CITY OF ALBUQUERQUE

August 14, 2019

Re: New Office Building
10601 Research Rd SE
Traffic Circulation Layout
Engineer's/Architect's Stamp 07-30-19 (M21-D021)

TRAFFIC CIRCULATION LAYOUT

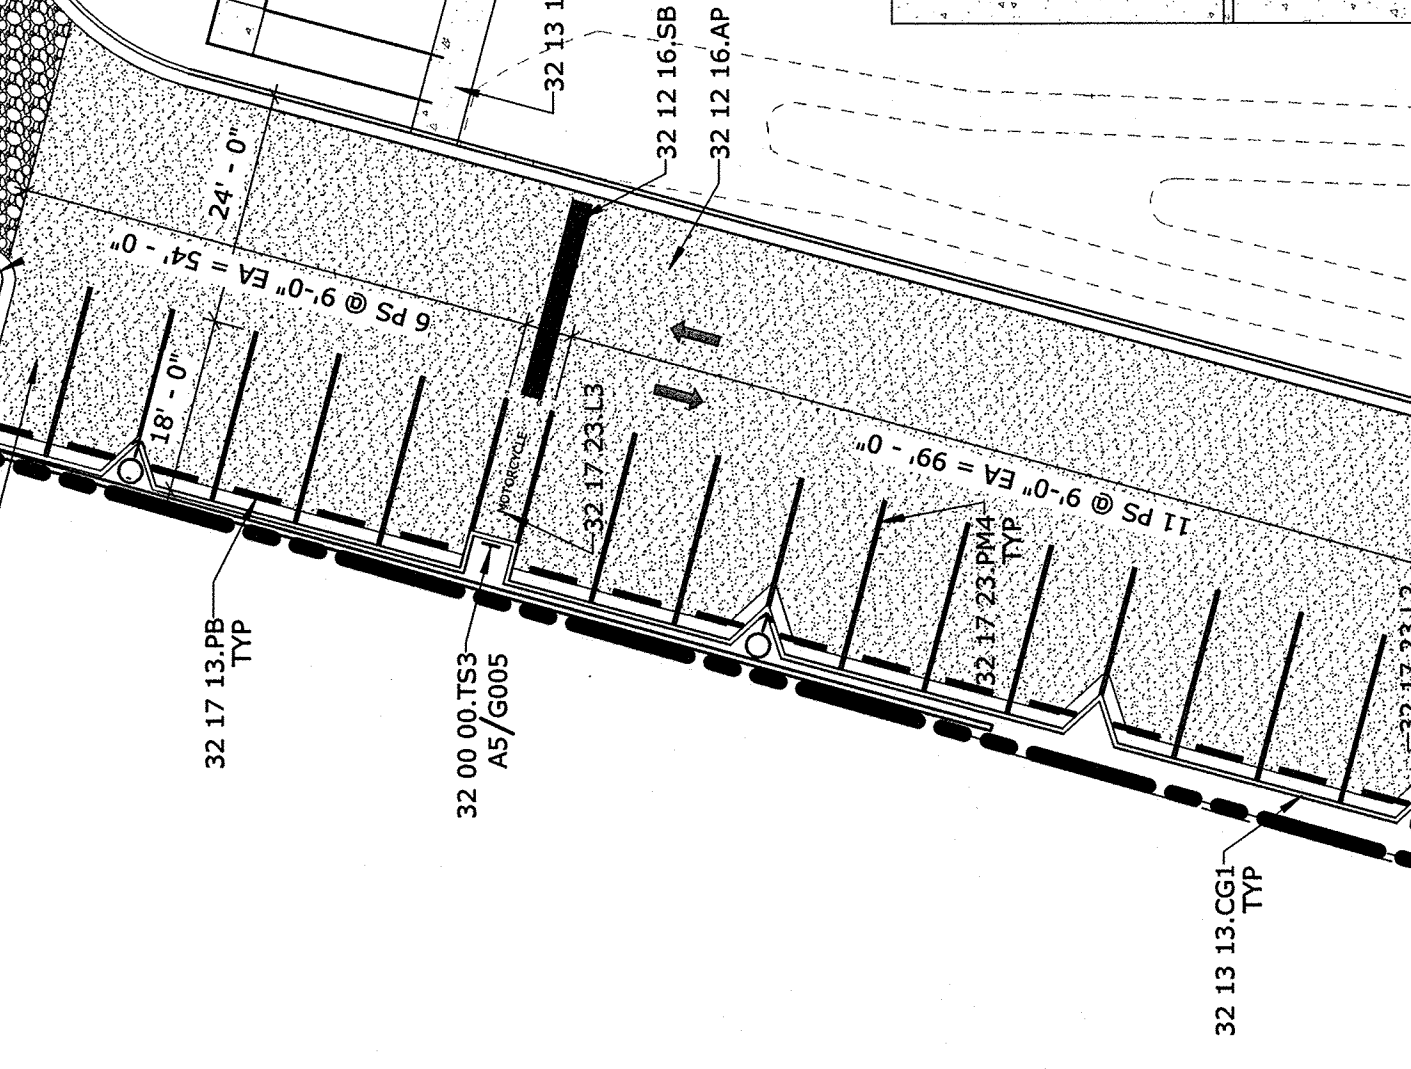
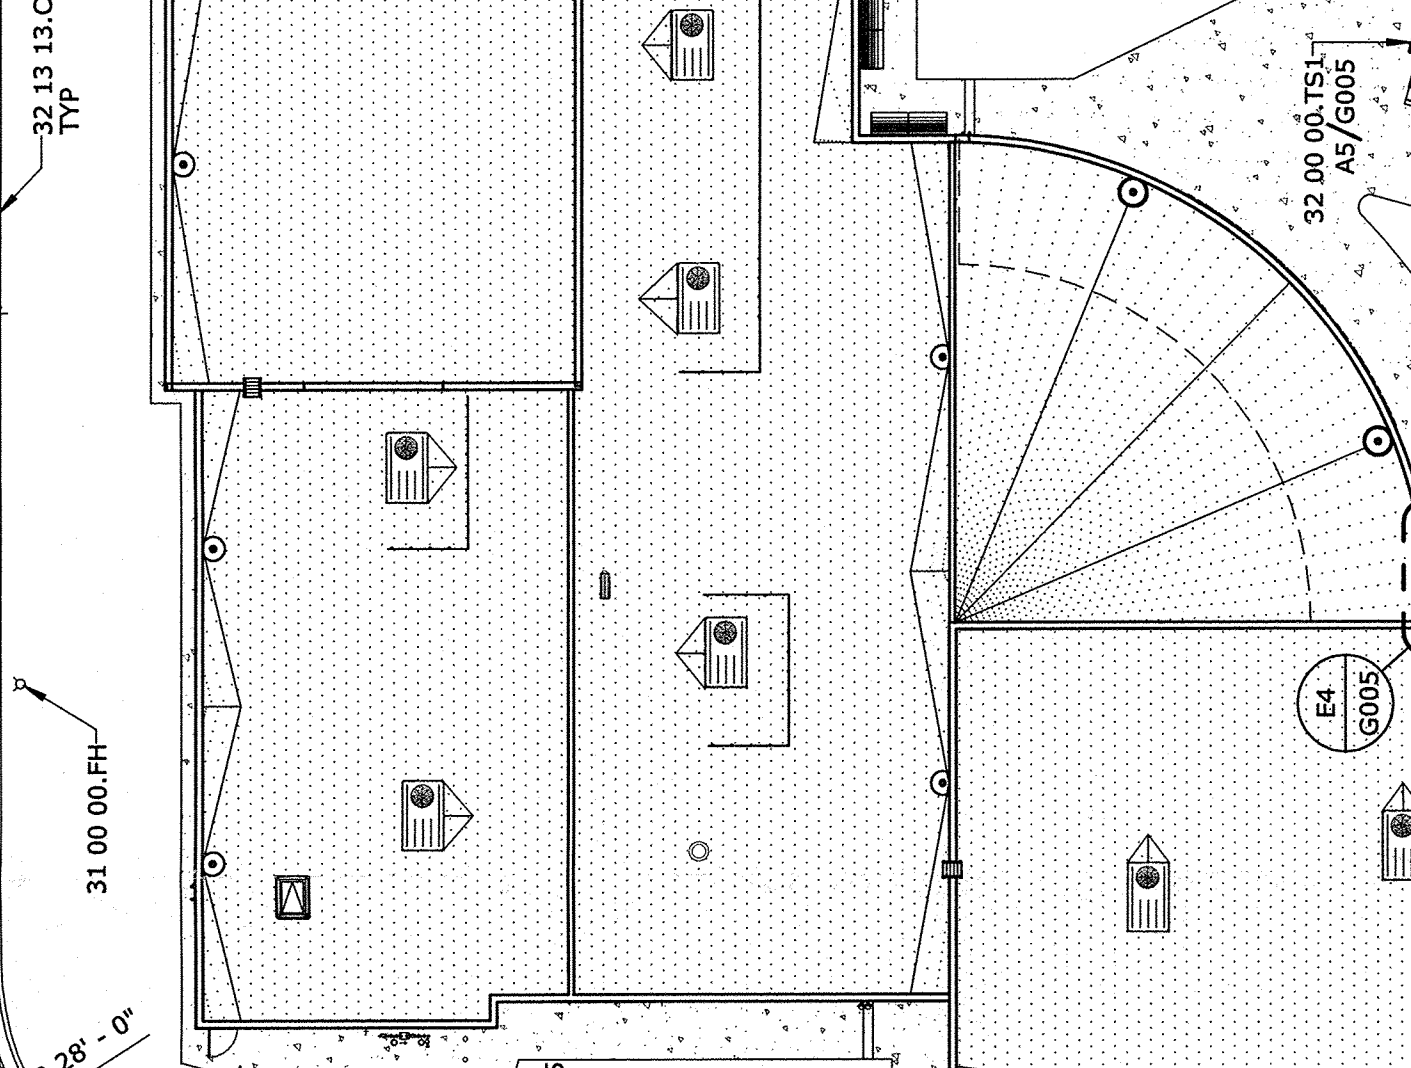
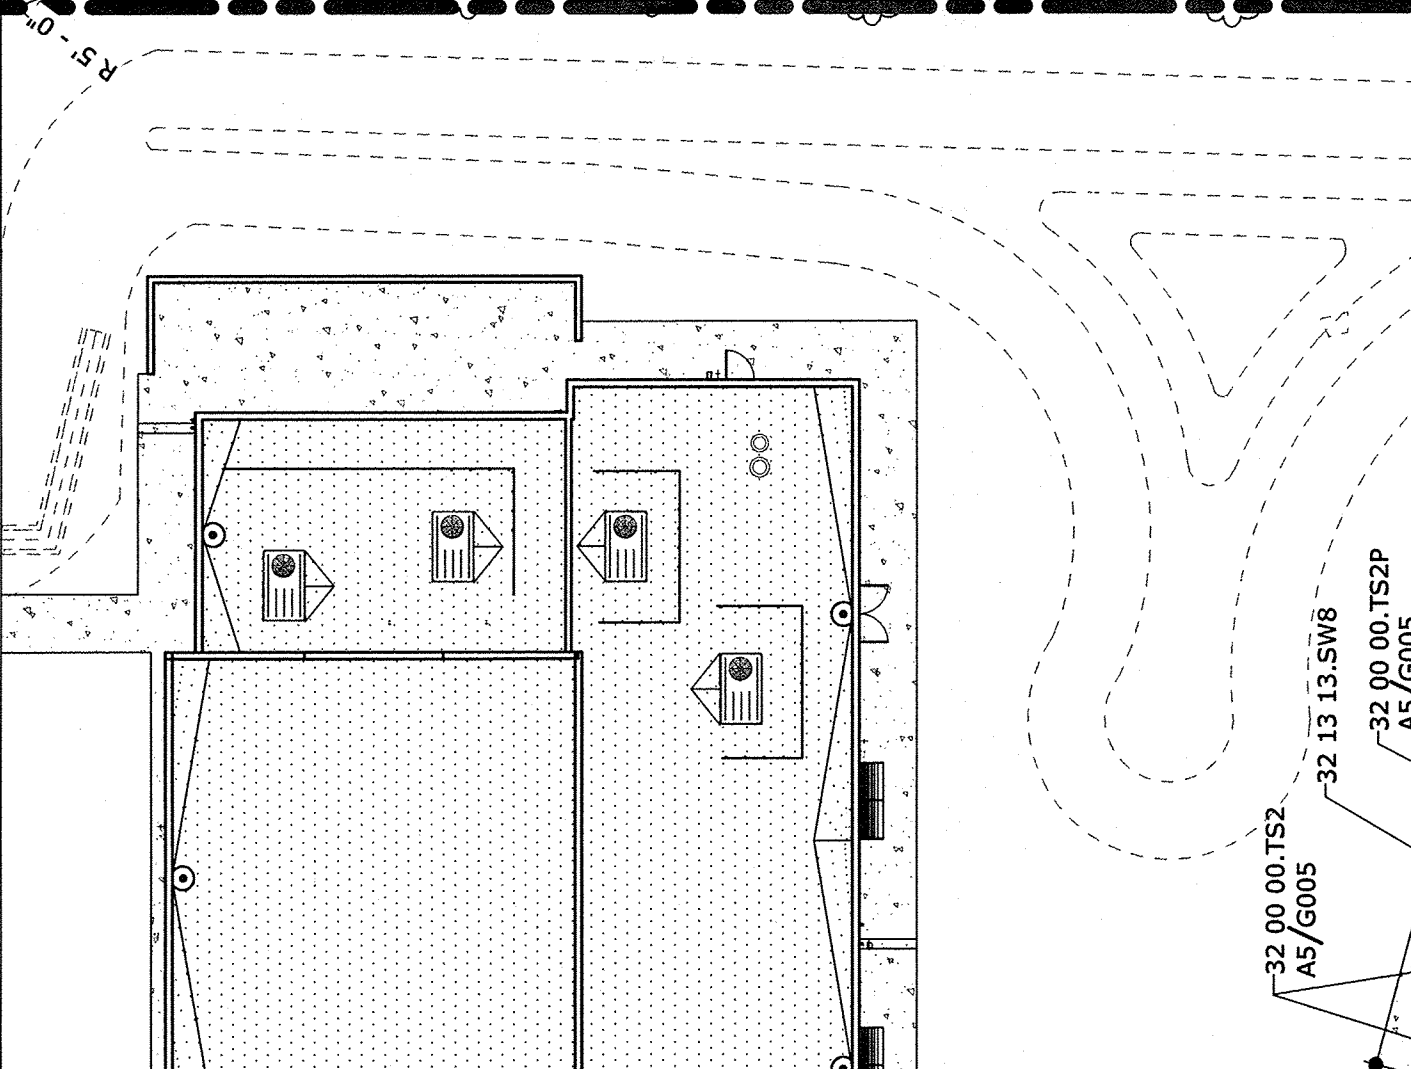
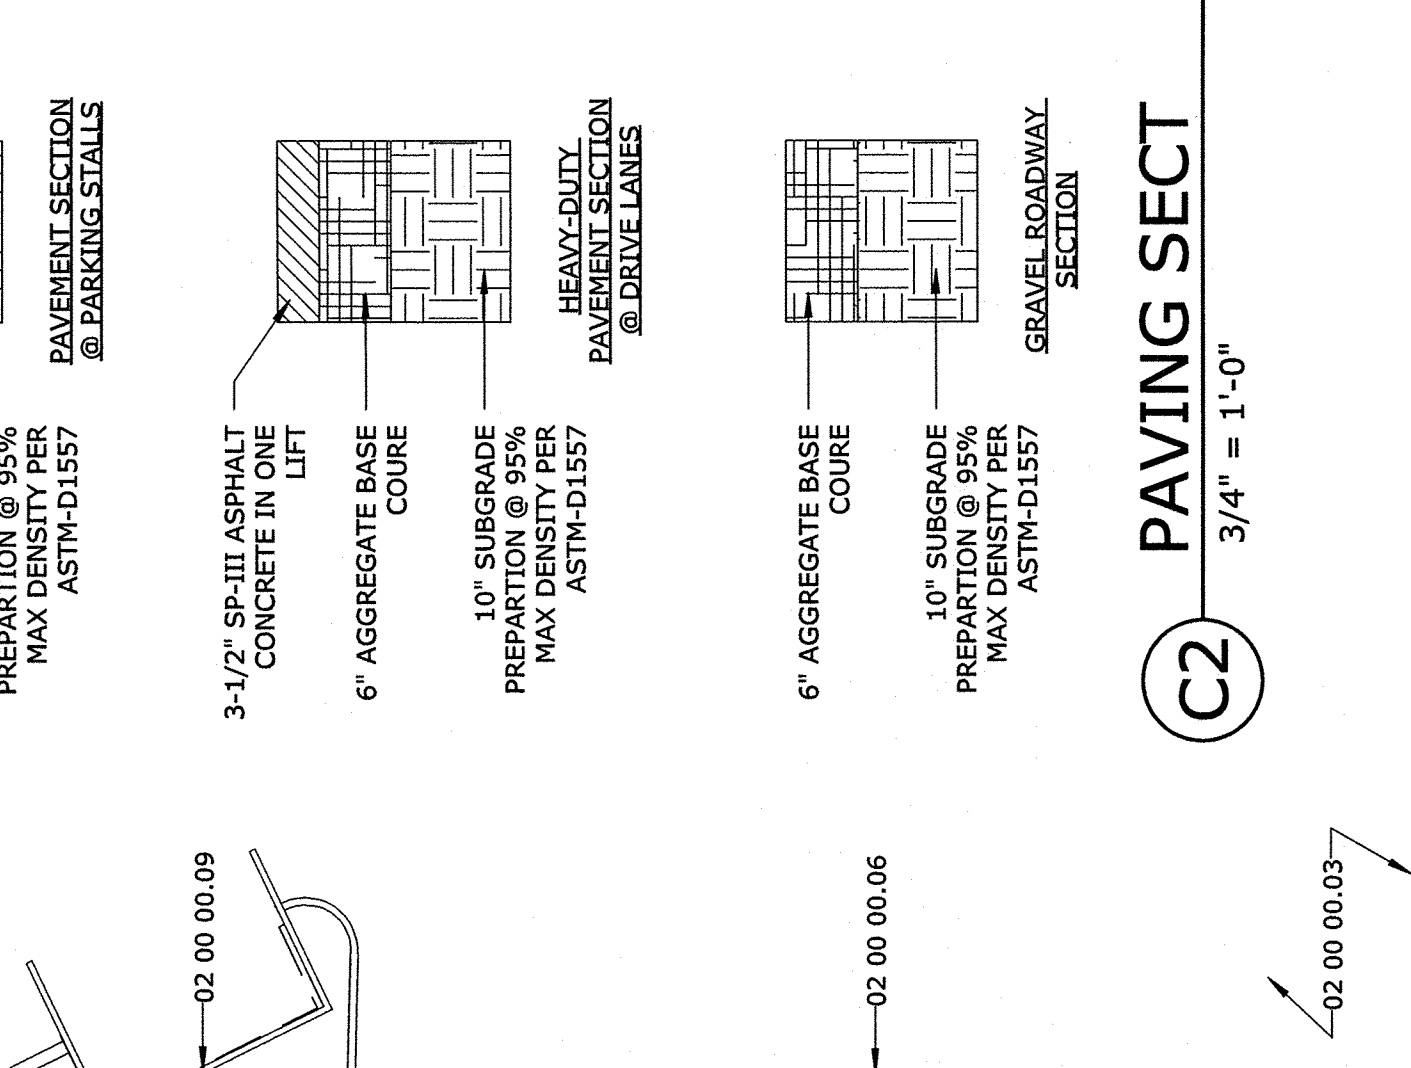
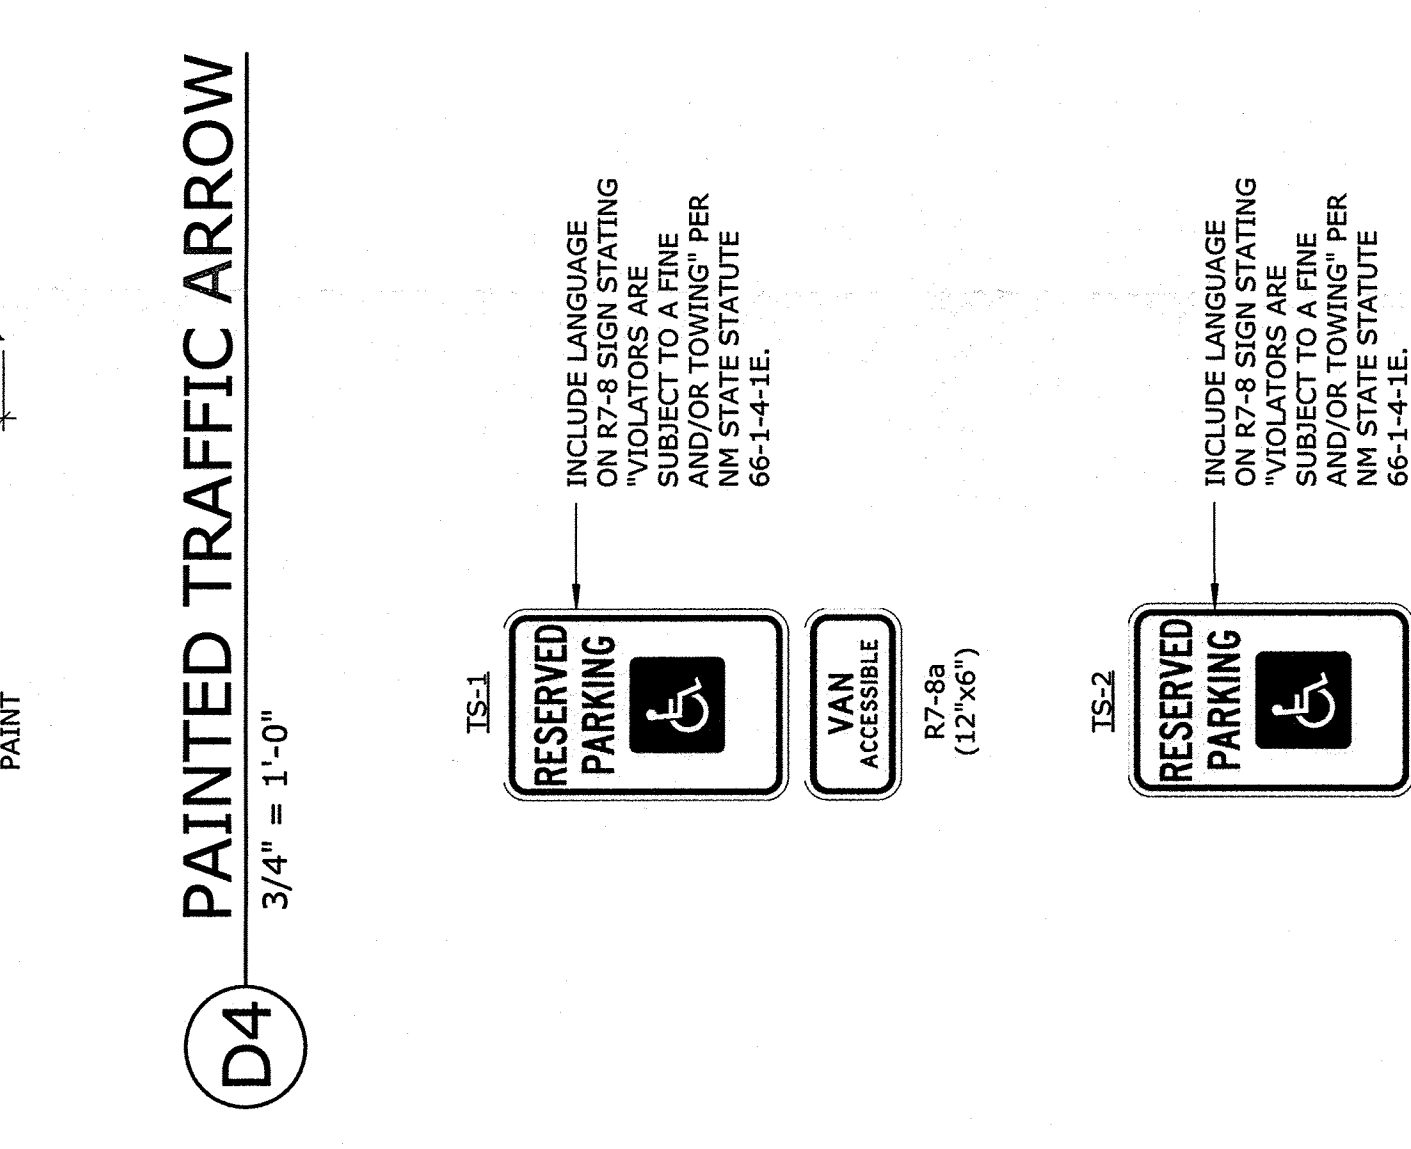
1. List the number of parking spaces required by the zoning code as well as the proposed number of parking spaces including bicycle and motorcycle parking.

2. Per the Development Process Manual, Chapter 27 Drafting Standards, "Standard sheets must be 24" by 36" having a margin of 2' along the left and 1"
3. Label the compact parking spaces by placing the words "**COMPACT**" on the pavement of each space.

4. All bicycle racks shall be designed according to the following guidelines:
 - a. The rack shall be a minimum 30 inches tall and 18 inches wide.
 - b. The bicycle frame shall be supported horizontally at two or more places. Comb/toaster racks are not allowed.

5. Bicycle racks shall be sturdy and anchored to a concrete pad.
6. A 1-foot clear zone around the bicycle parking stall shall be provided.
7. Bicycle parking spaces shall be at least 6 feet long and 2 feet wide.

8. Parking areas shall have barriers to prevent vehicles from extending over public sidewalk, public right-of-way, or abutting lots.

9. Refuse vehicle maneuvering shall be contained on-site. The refuse vehicle shall not back into the public right of way.; **provide a copy of refuse approval.**

10. It is not apparent what type of pavement surface is being proposed. A hard driving surface will be required as part of this proposed project for parking area and drive aisles.

11. Show the clear sight triangle and add the following note to the plan: "Landscaping and signage will not interfere with clear sight requirements. Therefore, signs, walls, trees, and shrubbery between 3 and 8 feet tall (as measured from the gutter pan) will not be acceptable in the clear sight triangle.

12. Shared Site access: driveways that straddle property lines, or are entirely on one property but are to be used by another property, shall have an access easement. Please include a copy of your shared access agreement with the adjacent property owner.
